## ASSESSMENT REPORT

47-50 The Esplanade, Ettalong Beach  
MP 09\_0121 MOD 4

On 18 June 2018, the Proponent lodged modification request 09\_0121 MOD 4.

The modification seeks to reconfigure the building plant on level 6 and use part of the area as private terraces for the adjoining units.

Project
PROPOSED MIXED USE DEVELOPMENT
47-50 THE ESPLANADE ETTALONG BEACH
Drawing Title
NORTH & SOUTH ELEVATIONS

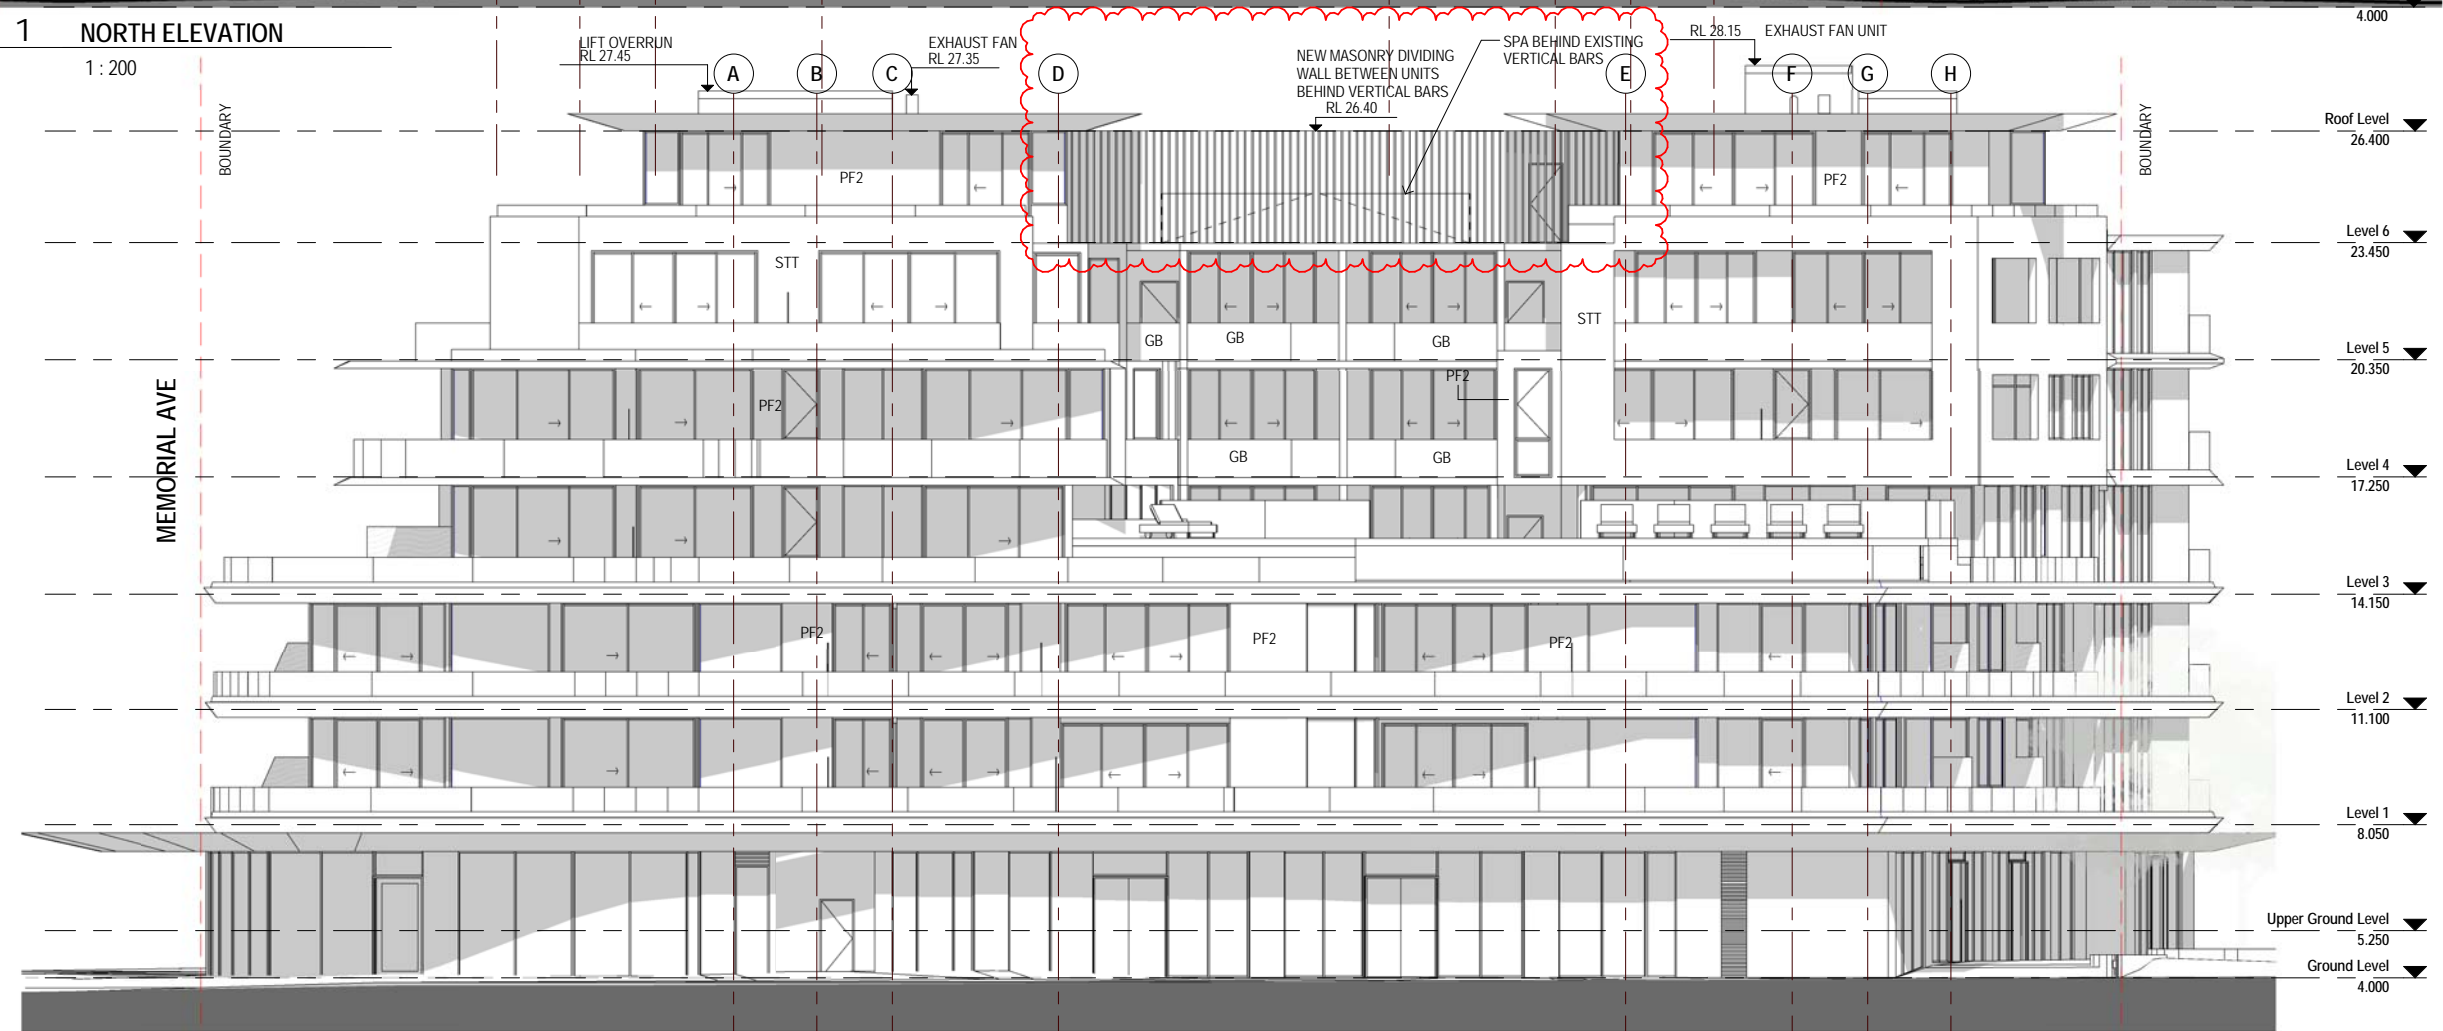
- impacts on surrounding properties;
- the potential visual impacts associated with the proposal would be mitigated by maintaining the previously approved vertical bars screening the proposed terraces and plant room. As shown in **Figure 3 and 4** the relocation of the plant room will not substantially alter the buildings appearance;

- potential overlooking from the proposed terraces towards other surrounding units would be appropriately mitigated by the retention of the previously approved screening (**Figure 4**) along the full frontage of the terraces;

FLOOR PLAN (COMPARISON SHEET)

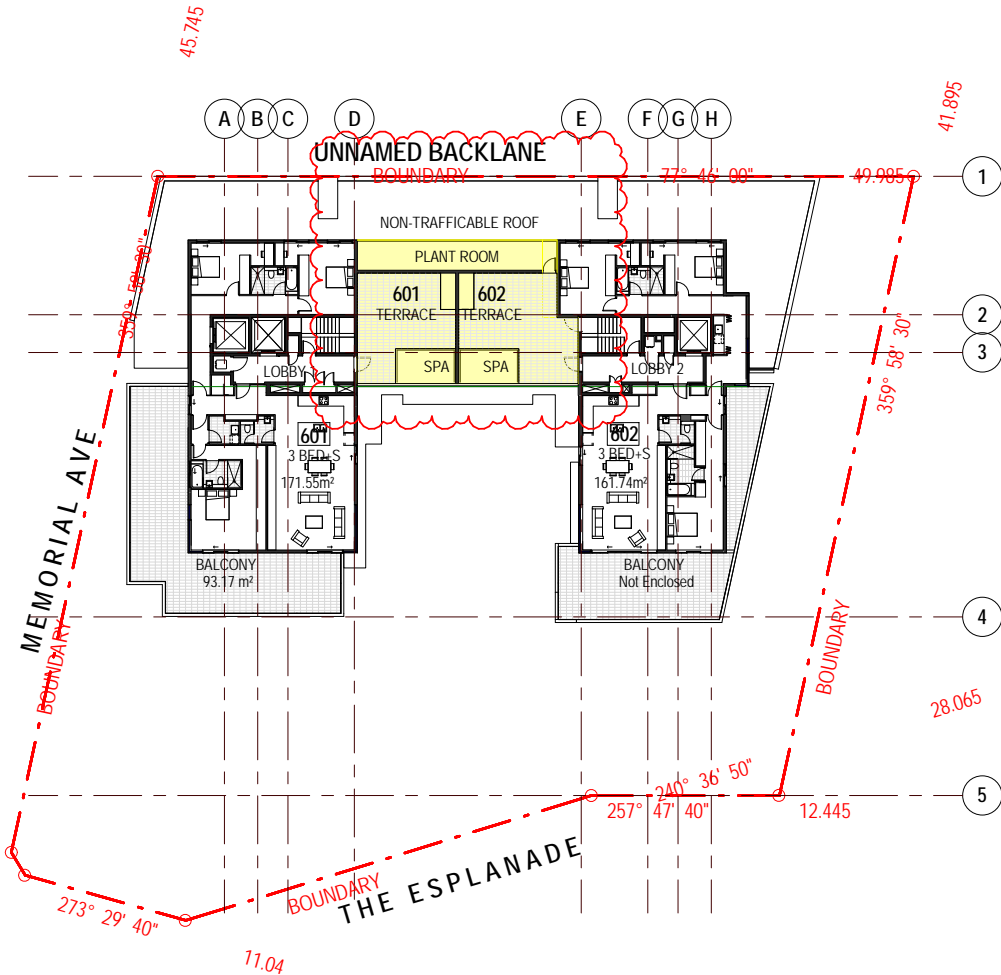
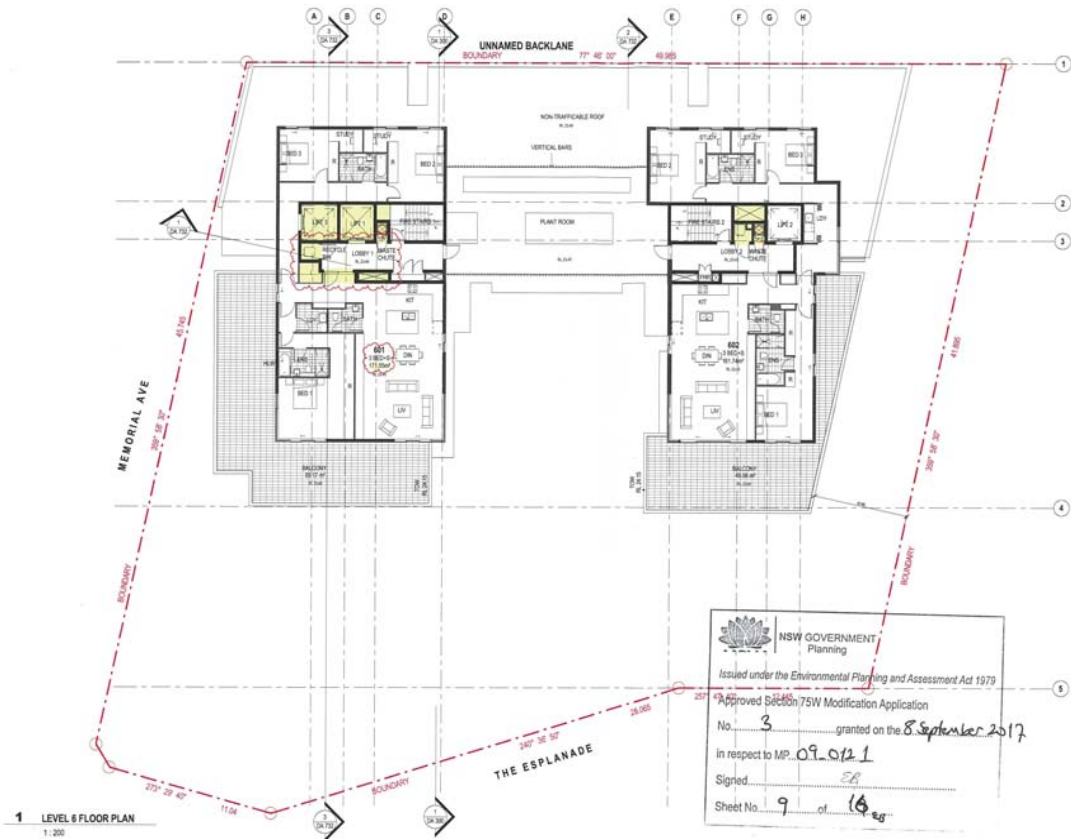
- potential amenity impacts between units 601 and 602 would be appropriately mitigated through the construction of the 2.95m masonry wall, separating the two terraces;

- the potential noise impacts associated with the relocation of the plant room will be mitigated through the use of double skin brick wall with a lined cavity, meeting the BCA requirements for noise between a plant room and bedroom space.
